Sheet-LA1.1 (page 1 of 6)

1. Provide written documentation from the owner of 5001 E Mercer Way describing the extent and duration of the access.
Written documentation from the owner of 5001 E. Mercer Way has been included with this submittal, see Authorization letters.
2. Where are erosion control measures?
Erosion control measures are demonstrated on the Wall Excavation Plan, Sheet LA2.2
3. The hardscape numbers do not match the Site Development Worksheet. Please double check and update and resubmit the plans and Site Development Worksheet as necessary. Please remember that decks count as hardscape.
The site development worksheet has been updated to the current format released by the City of Mercer Island in January of 2020. Changes are reflected on Sheet LA1.1

Nov 14, 2019 11:50:04am - User: Keith Jankovsky
 N:\PROJECTS\2551 SARAH & AMR BASTIAROWSKI\2551.01 THE MAPLE GROVE RESIDENCE\PHASE 03 - PERMIT ASSISTANCE\CAD\2551-LA1.2 TREE RETENTION PLAN-MAPLE PERMIT.DWG

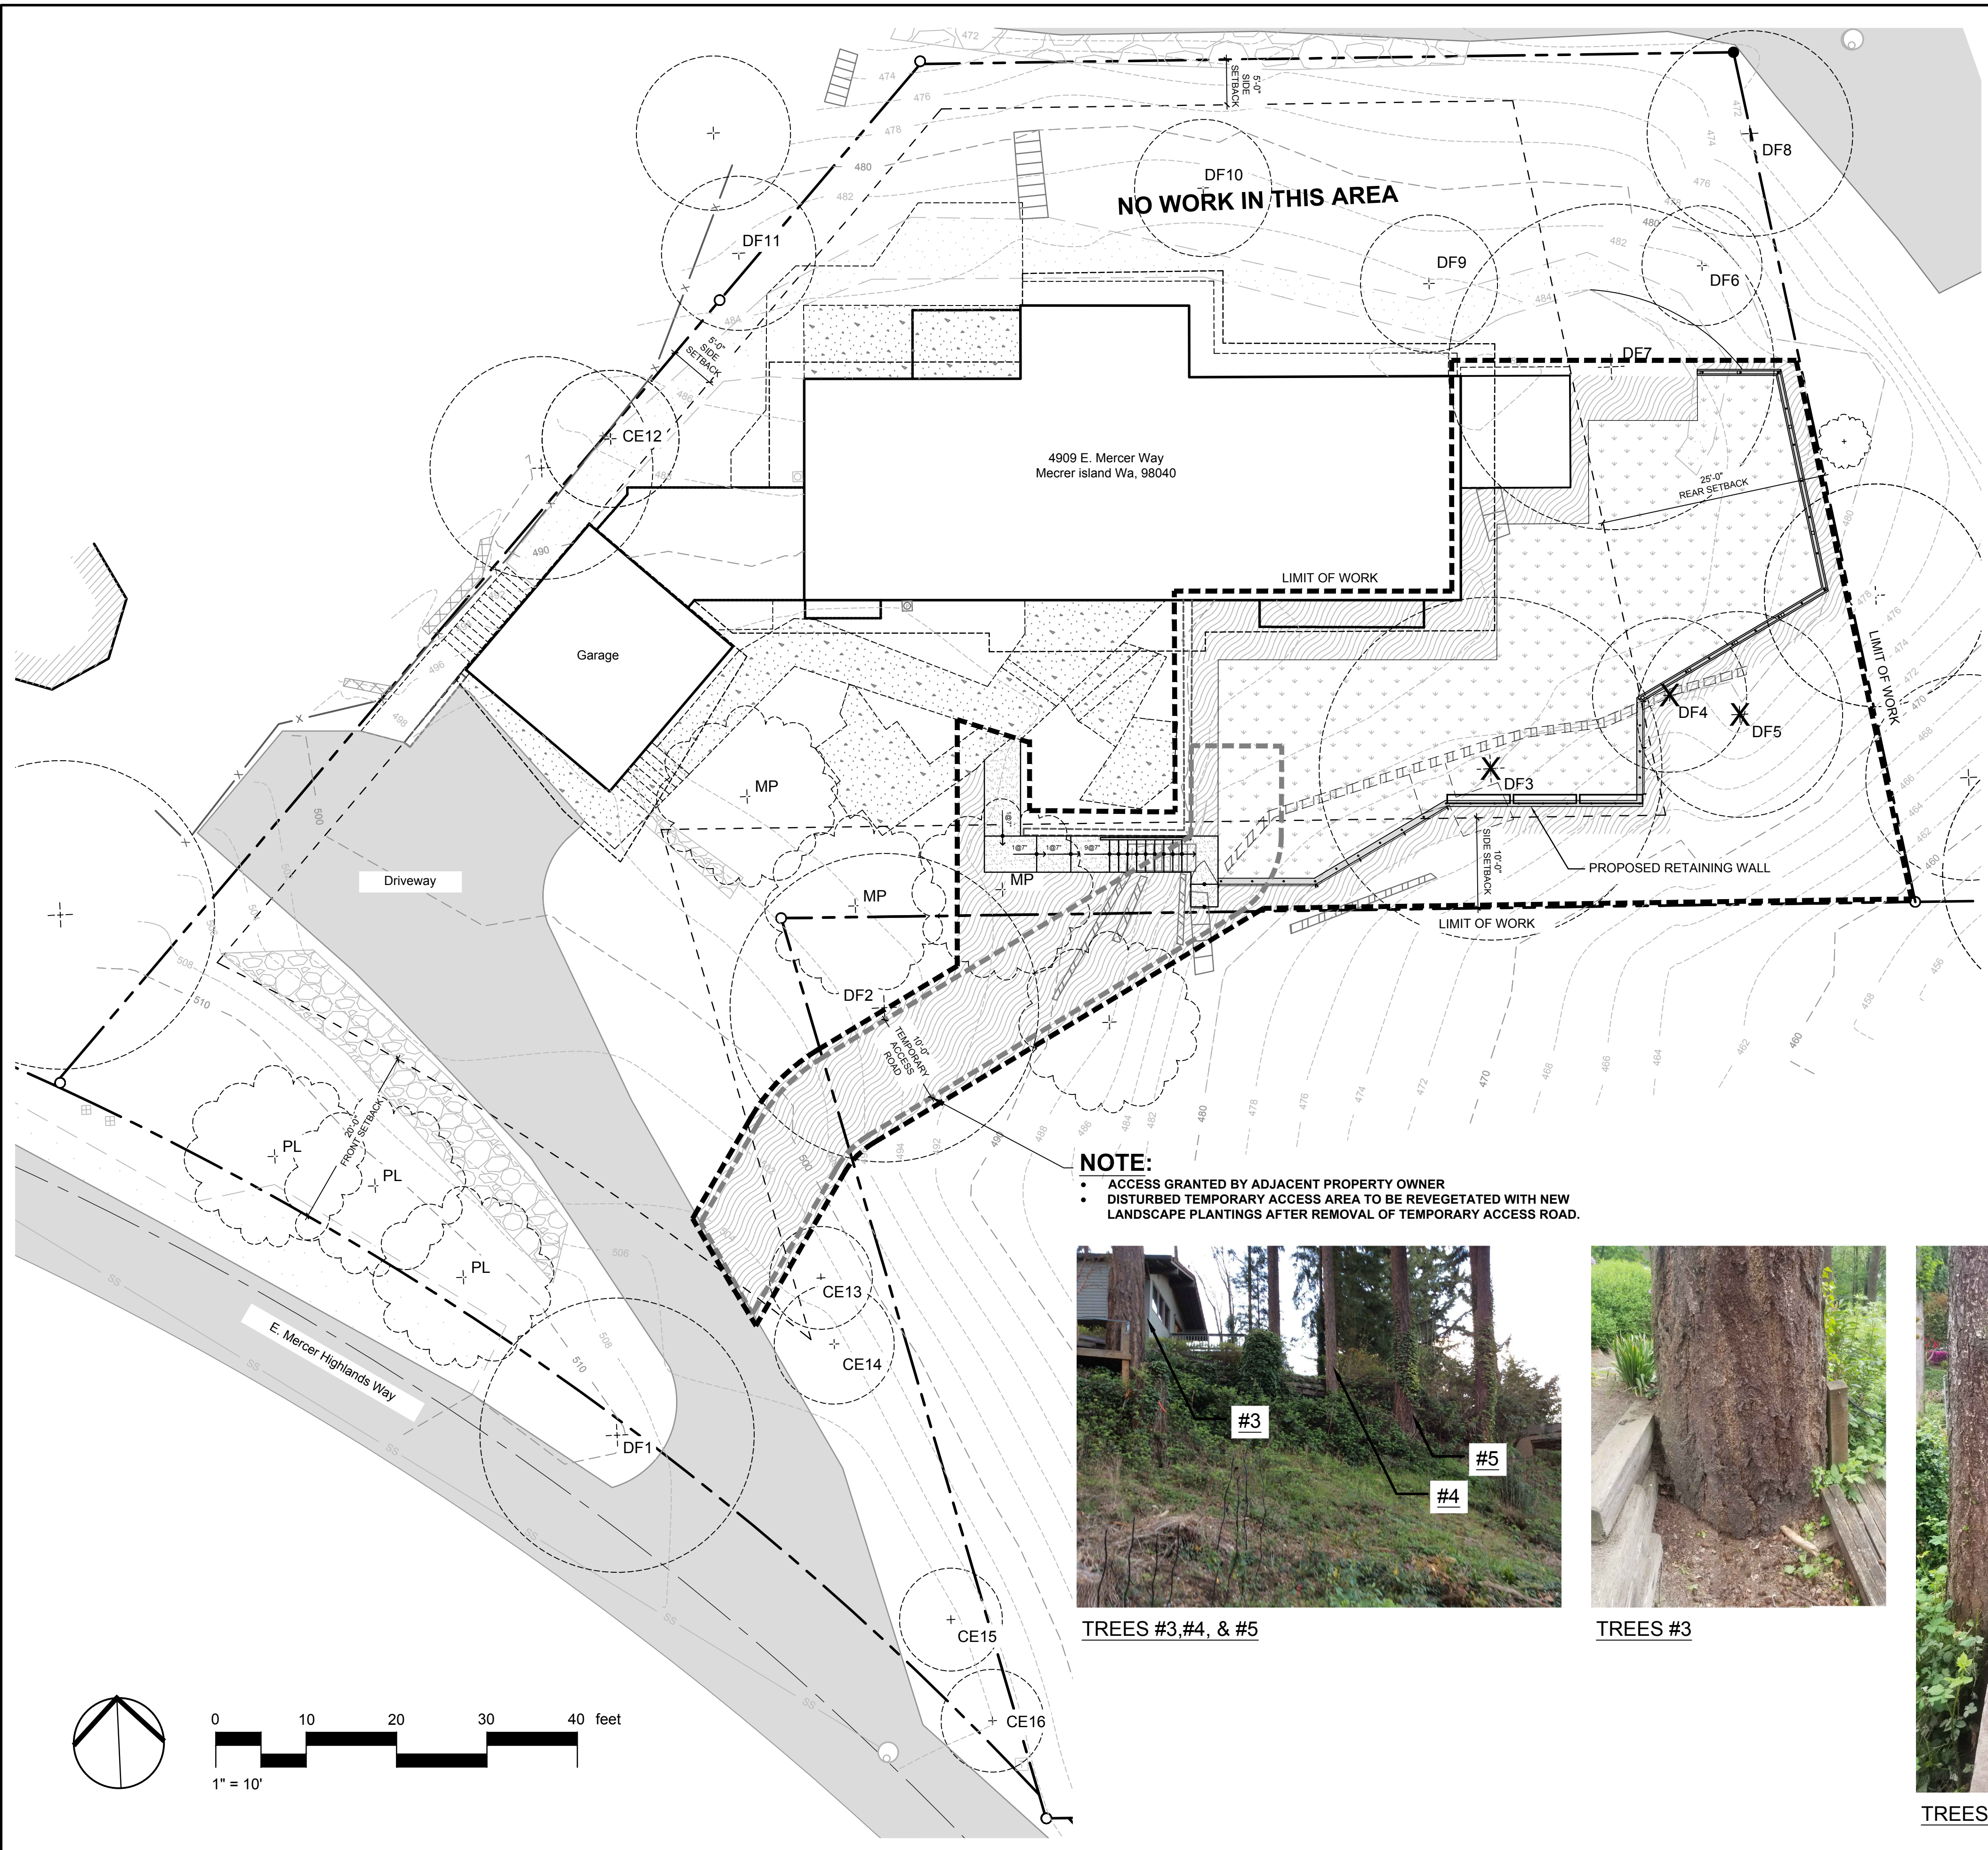
4. The temporary access road on adjacent property appears to go over tree DF2 and two MP trees. These trees most likely be damaged and removed for this access. Provide written permission from adjacent property owner for the easement/access road and tree removal. Replacements for these trees and all replacement trees, locations must be shown on the plans.
The proposed location for the temporary access road has changed on the plans for reasons of construction cost. Please note that DF2 will be unaffected. One existing Japanese Maple will be removed for the access road. This maple has a caliper less than 10" so it is not subject to regulation. The owner plans to replace this Tree with a new Maple, subject to current nursery stock availability, that is alike in size and kind.

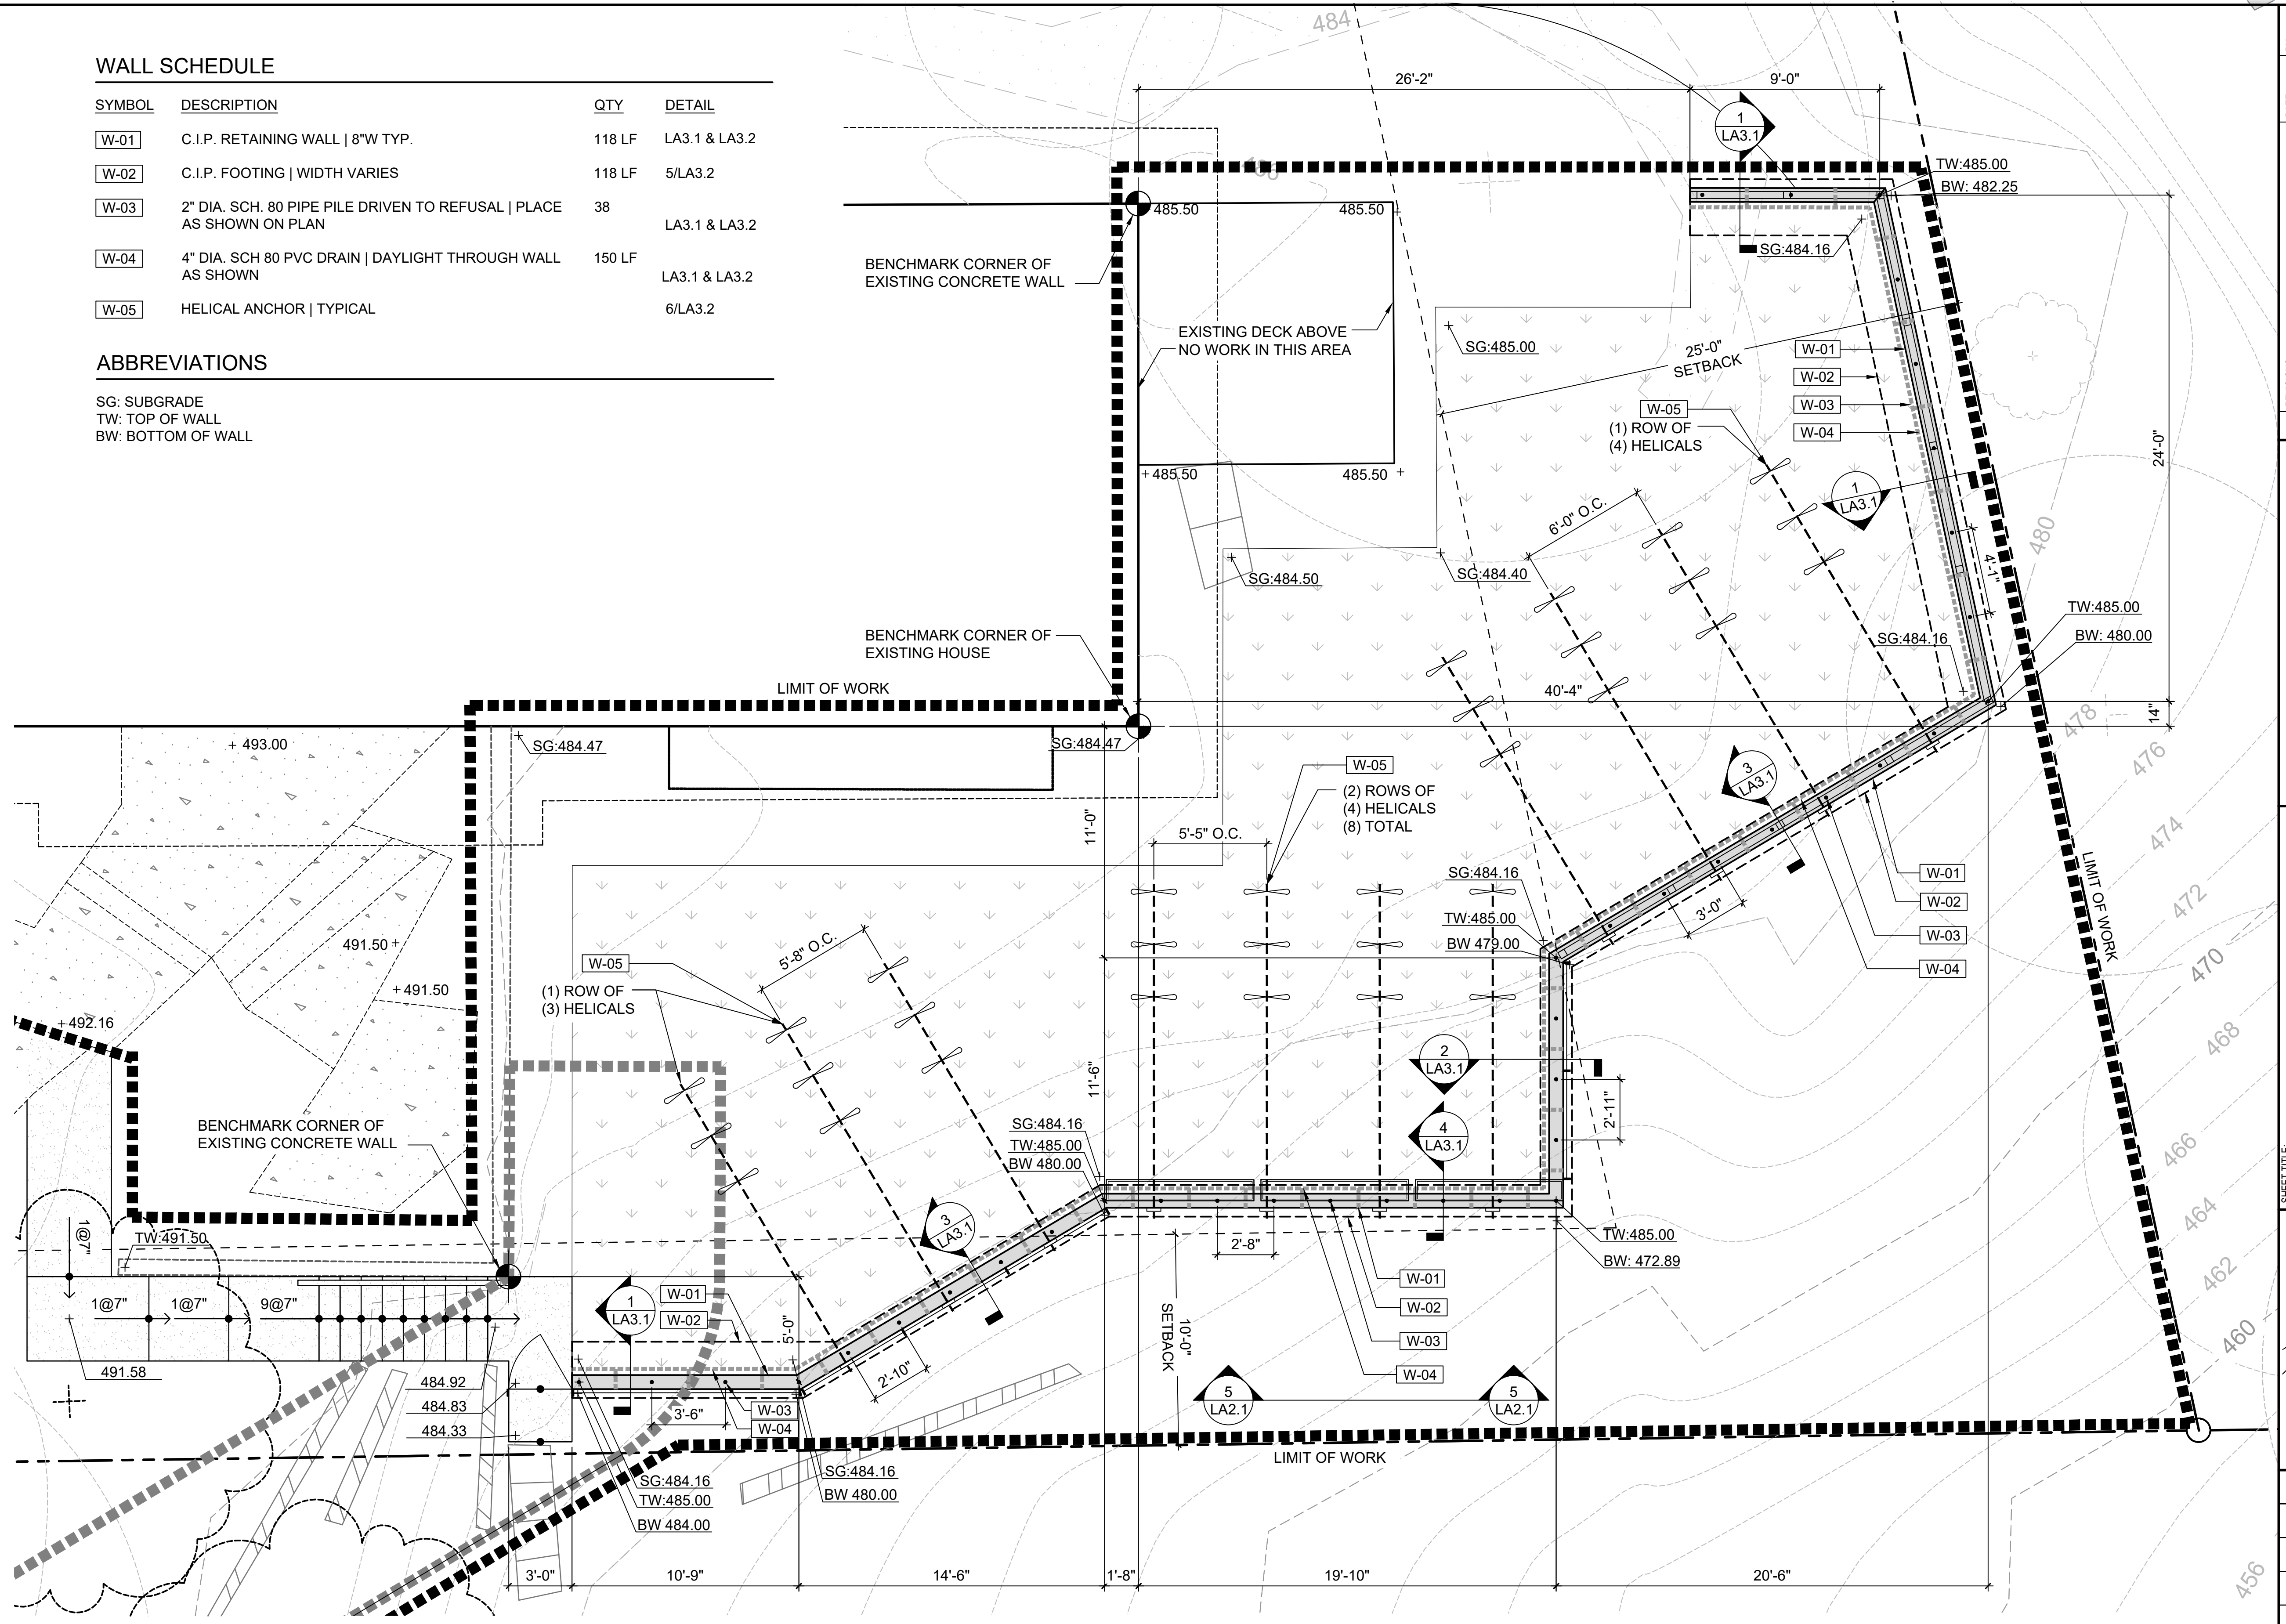
5. Draining through wall should not be allowed onto slope. Provide means to collect and discharge drainage away from slope.
Drainage for the wall will be collected by footing drain and tight lined to the nearest storm catch basin. Please see Wall Drain Plan and Details on Sheets LA2.3 - LA2.5

6. Verify that the anchors do not adversely impact existing structural or utility elements on site.
Helical tieback anchors have been removed from the plan and replaced with vertically driven W piles. Note 3, paragraph 2 instructs the contractor to locate all underground utilities and maintain clearance from them. Little to no ground movement is expected with the installation of the piles and tiebacks.

7. Tieback loads and wall moments for wall 3 are calculated on page 2 of calcs. Please annotate the calculation on this sheet starting with "calculate x." Is this finding the value and location of max moment? I'm not familiar with the max moment formula for a double cantilever with varying load, and I can't find a wall reinforcement design that corresponds to the $M=8.83$
Tiebacks have been removed and replaced with a cantilever soldier pile wall. See attached calculations.

8. This wall design did not include the surcharge loading from the steel planter boxes.
The steel planter boxes have been removed from the design.
9. You are proposing 12 feet of fill on a slope. Geotechnical engineer to provide site preparation and structural fill placement recommendations for this sloped condition. Are you notching the fill into the slope? Provide a detail.

10. Calculations indicate W4 is intended to span horizontally between adjacent walls. Clarify the impact of these loads on the tiebacks as the spacing is no longer the 6' assumed in calculations. Clarify the extent of the horizontal reinforcement necessary (this bar would need to continue to and develop beyond the restraint at the tieback location to span between these anchors, not stop at the wall corner or develop beyond the corner).

11. Provide an overall static and seismic slope stability analyses of the final slope configuration with the new 12-ft high wall. Provide cross-section and stability results in geotechnical addendum letter to design report. Include minimum risk statement following review of revised plans.

12. How do you intend to install the helical anchors? Are you proposing temporary grading on the outboard slope to provide construction access for equipment? Provide temporary grading plan showing extent of slope disturbance and degree of disturbance.

13. ESNW report 2/5/19 and sections on LA3.1 indicate the proposed wall will be constructed using temporary benches and toe slope open cuts. Provide an excavation plan reflecting the anticipated bottom of excavation and all temporary slopes to accommodate the installation of all wall, foundation, and drainage system including footing step locations.

The 12-foot section of the wall has been removed and the tallest portion of the wall is now only 6-feet high. Please see revised geotechnical report for structural fill information and revised plans for updated wall layout.

This condition has been eliminated with a revision of a cantilever soldier pile wall.

The SSSA report and statement of risk have been provided in this submittal, however, the 12-foot high section has been removed per #9 above.

Helical anchors have been removed from the plans. W piles will be installed instead, using the same methodology as driven pipe piles. See attached revised structural calculations.

Please see the Wall Excavation Plan on sheet LA2.2.

14. PIN PILES:

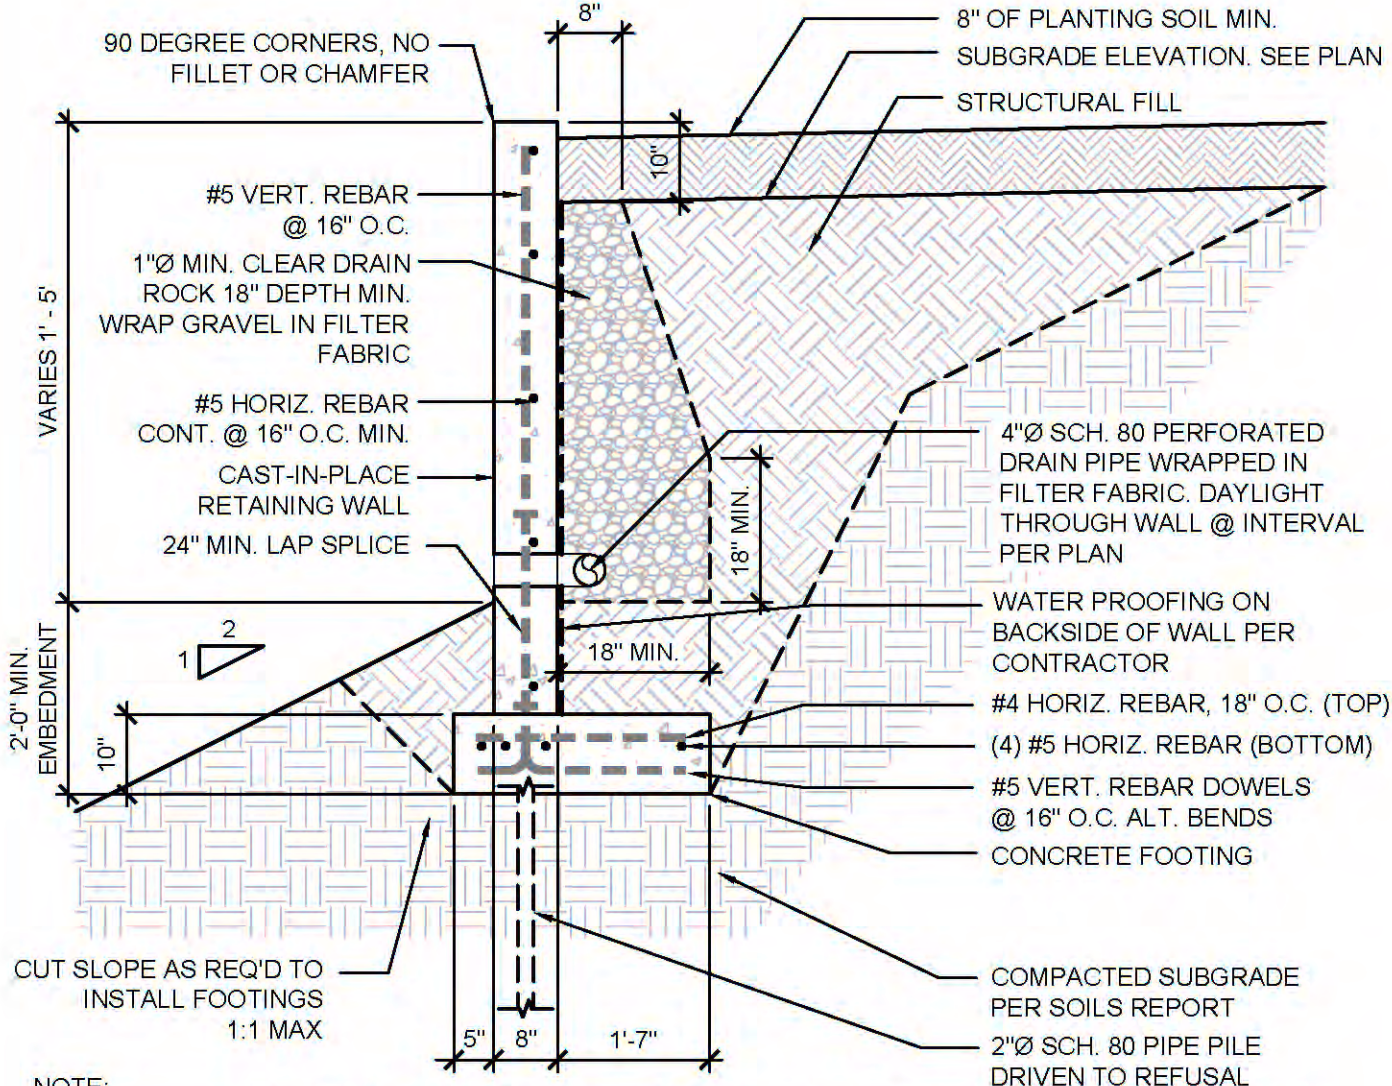
14. Driven pile installation should be continuous not periodic.

15. The maximum 2-inch diameter pin pile capacity without pile load testing is 2 tons. With a 3 T design load, provide pile load testing.

16. Given the sloping ground conditions ranging from 1.4H:1V to 2H:1V in front of the walls, provide a minimum pile embedment length to ensure adequate pile support.

17. The pin piles were described as grouted pipe pile in the geotechnical report. Where is the grout provision in this design?

Periodic inspection for the piles has been changed to continuous.

Testing requirements have been added for the pipe piles.

The geotechnical engineer has indicated that refusal will be encountered at depths beginning at 6' bgs. Note 14 currently requires that pipe piles shall have the additional requirement of being embedded 10 feet below grade. The geotechnical engineer has also stated that the contractor shall be prepared to drive piles as much as 20, depending on the existing conditions. No changes required to this note.

The geotechnical report has been revised and grouting is not necessary or recommended.
